**Consultation Response from Mike Hibbert,
KC Waste Strategy(Refuse & Recycling)**

2024/91497 Land at, Yew Tree Road, Birchencliffe, Huddersfield, HD2 2EQ

Discharge conditions 2 (materials), 4 (highways), 7 (landscape), 8 and 9 (bin stores), 10 (crime prevention), 11 (boundary), 12 (lighting), 16 (highway structures) on previous permission 2021/94363 for reserved matters application pursuant to outline permission 2018/90151 for erection of 17 dwellings

Date Responded: 03/07/2024.

DRG. No. 2313-0314-P02

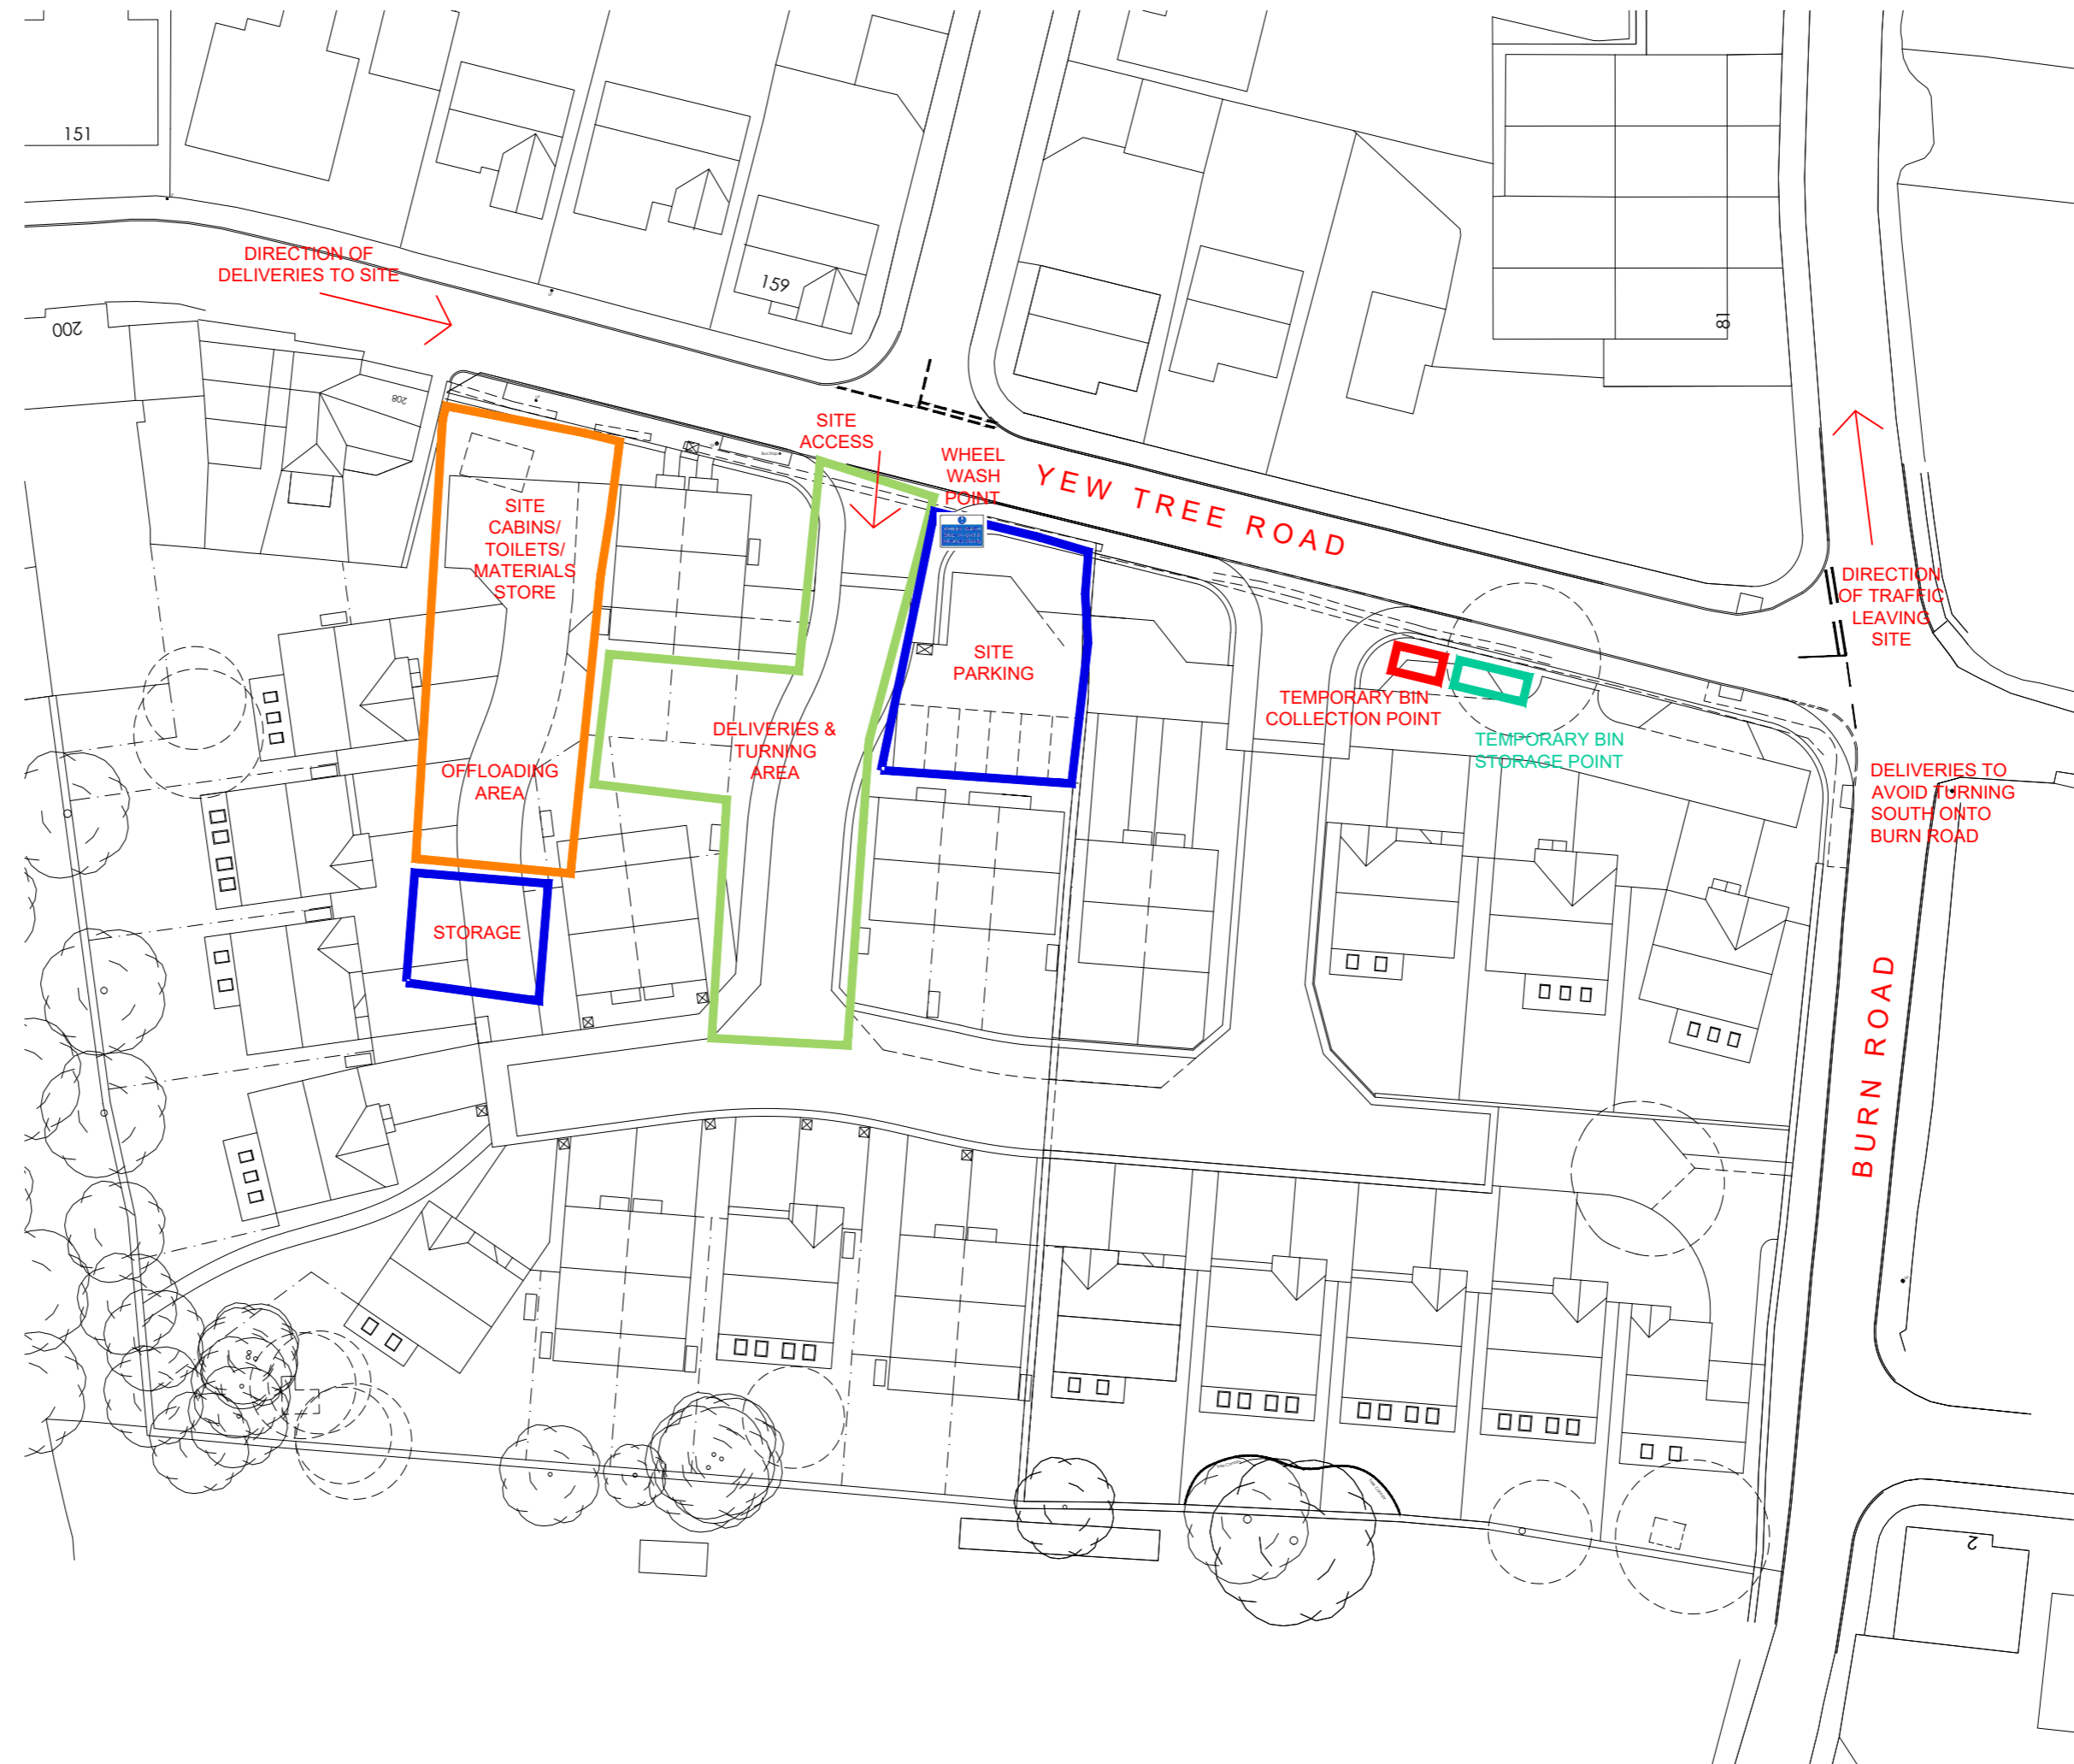
The applicant has submitted Construction Plan DRG No 2313-0314-PO2 dated 21/05/2024 for phasing of the works and temporary arrangements for storage and collection of bins.

The plan is annotated, with the location of temporary bin collection point (in Red and Green) for use during occupation by new residents.

- The Waste Collection Authority will not enter active construction sites with a Refuse Collection Vehicle (RCV). The rationale is to avoid damage to RCV's due to inadequate roadways, potential impact between RCV's or collection crew with contractors' plant/ delivery vehicles and remove the necessity for collection staff to undertake mandatory health and safety induction by the site manager.

- The WCA would appreciate the opportunity to meet on site with the site manager to discuss and confirm requirements in relation to access and waste collection points once residents start to occupy properties.

- For future phases, if an RCV is entering a site to service properties or a temporary waste store, then there must be demarcation such that a turning head is fenced off from the active construction site. Long reversing manoeuvres by RCV's is a recognised safety risk for both collection staff and members of the public and must be avoided.

Once a meeting has taken place at commencement of construction to establish on-site arrangements the WCA will be willing to confirm discharge of Condition 8.
